# ridge1 street review2.pdf Markup Summary

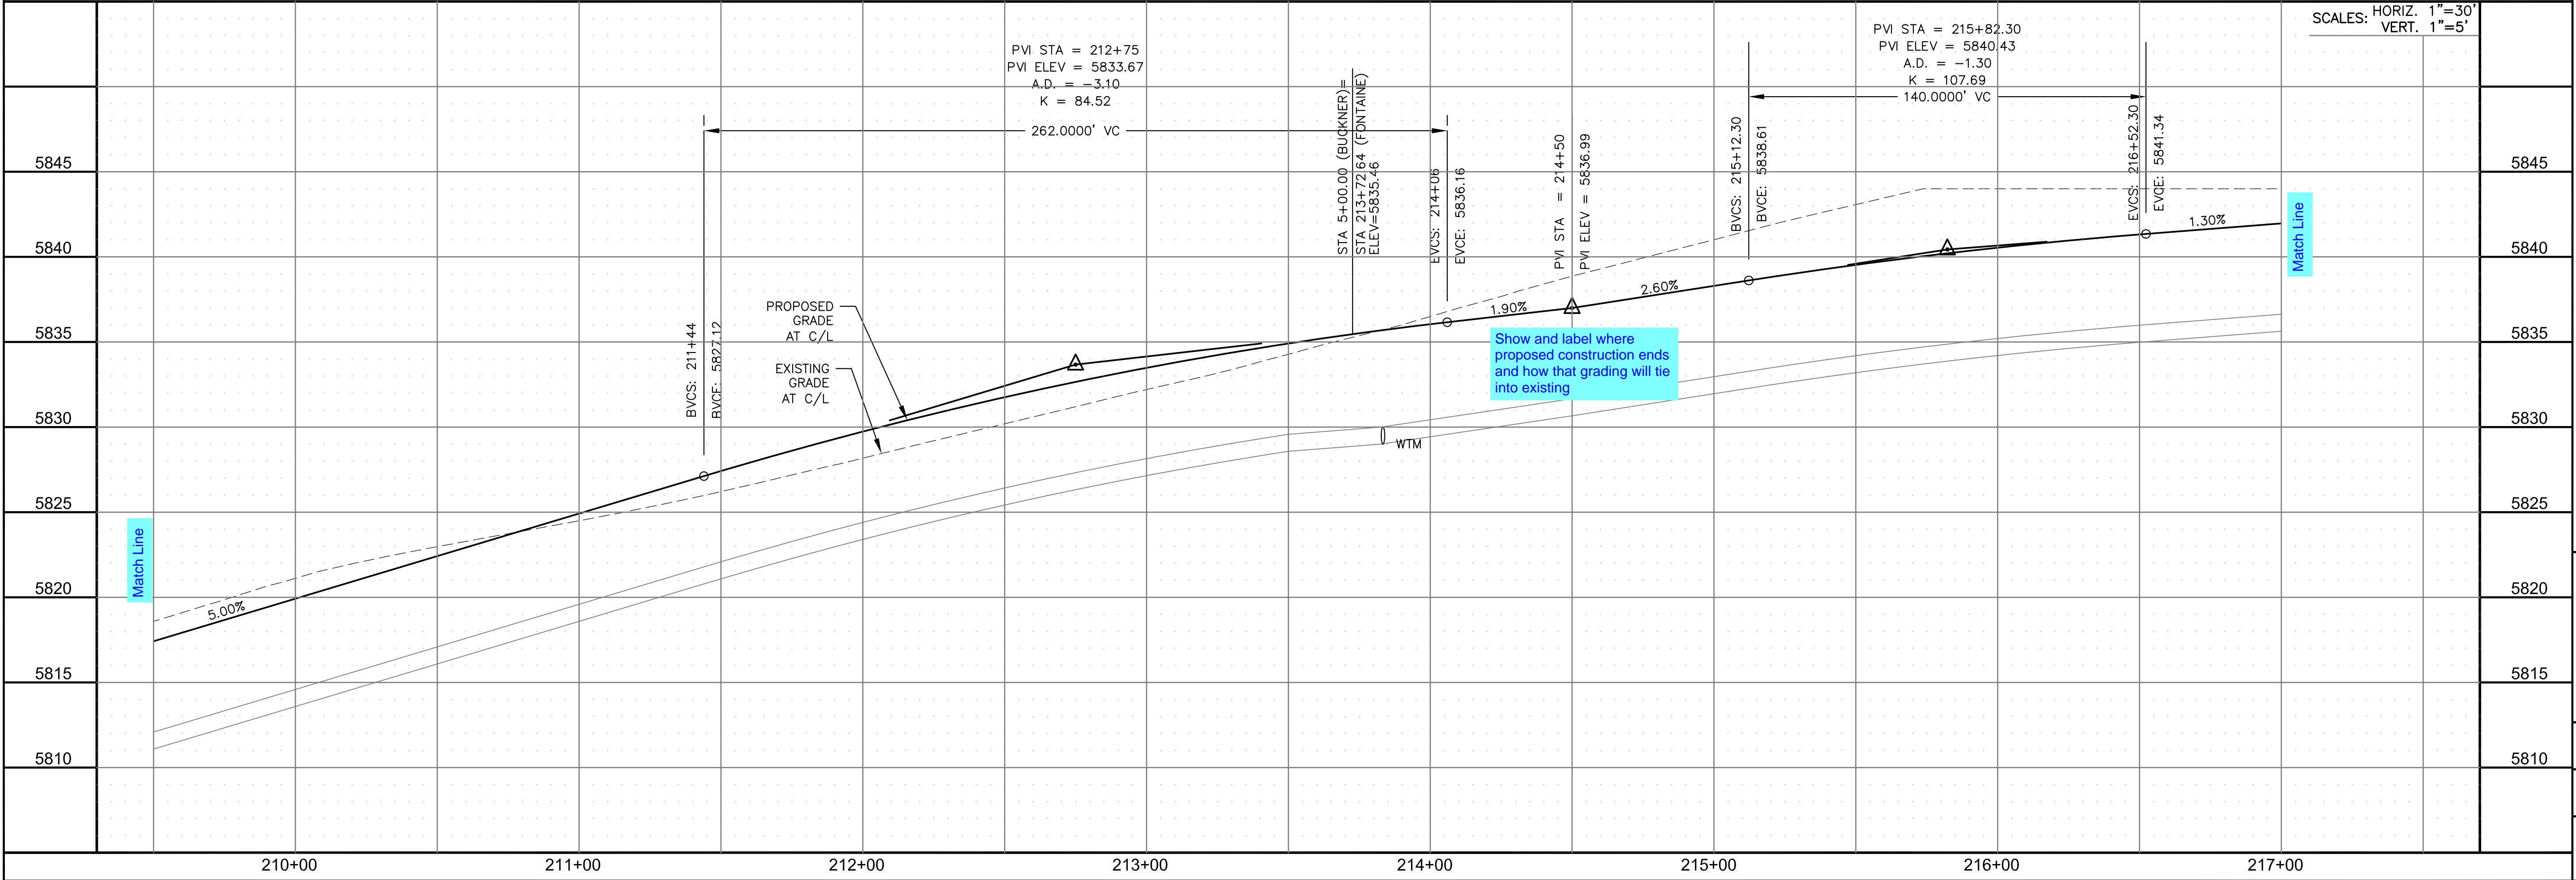
Show and label where proposed construction ends at Sta 214+14.64 and show how that grading will tie into existing until future construction is done

LABEL ADDED. FONTAINE WILL BE ROUGH GRADED TO 221+15
